About the application

Application number: 2023/92695	
What is the application for?:	Change of use and alterations to workshop to create two dwellings
Address of the site or building:	Crown Buildings, Scott Hill, Clayton West, Huddersfield, HD8 9PE
Postcode:

Only figured dimensions should be used.
Scaled dimensions should be checked with the Architect.
This drawing together with the design, is the property and copyright of the Architect and must not be reproduced without written permission

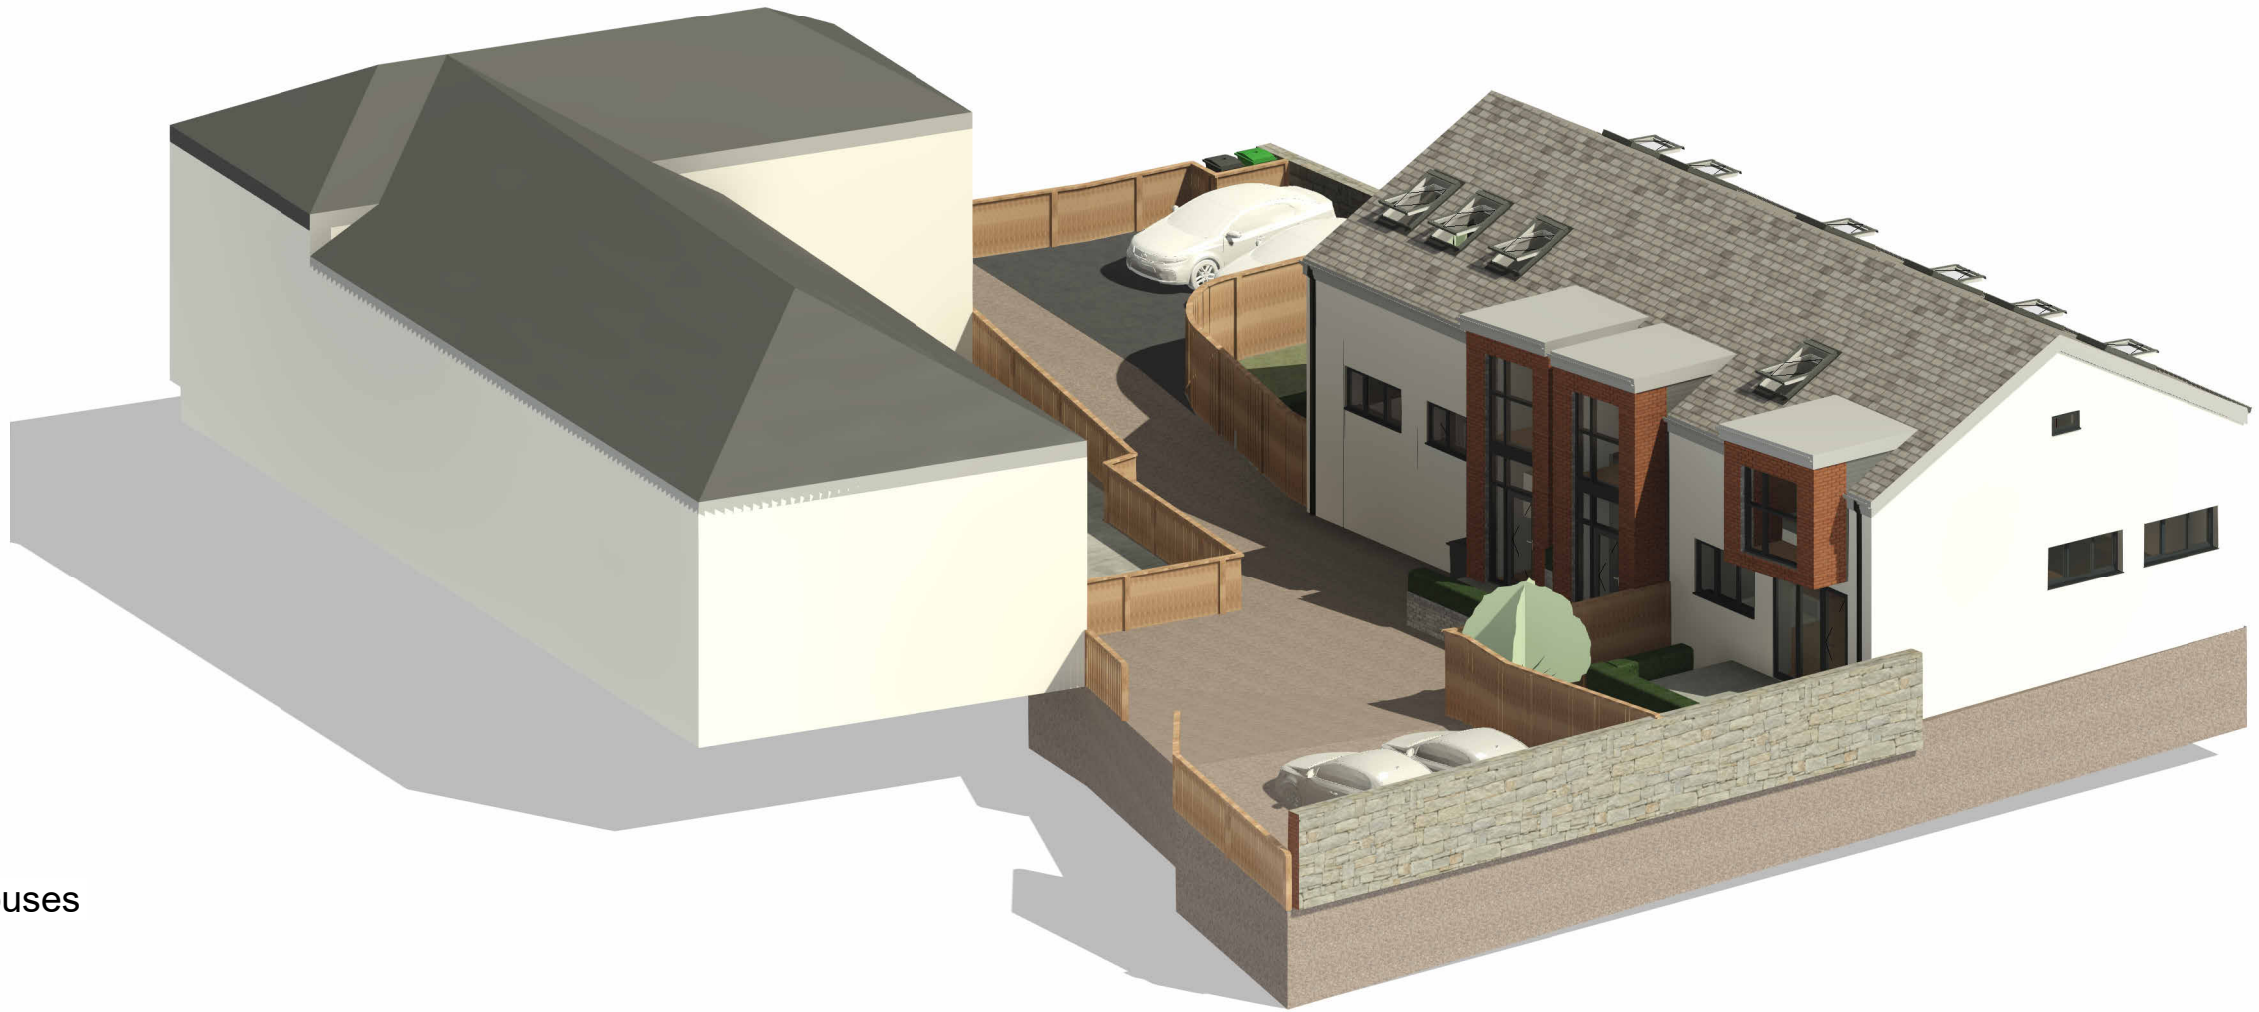
Type of comment: An objection	
Do you wish your comments to be published on the website anonymously?	Yes
I object to the planning application due to a loss of privacy as plans show non obscured glass windows overlook habitable rooms in my house and my garden. I object to the car parking area identified at the rear of the property. Highway safety on the blind bend at Scott Hill will be affected if cars cannot be manoeuvred to turn around and exit safely due to a lack of space and the area is reduced with proposed entrance door dormer columns protruding.
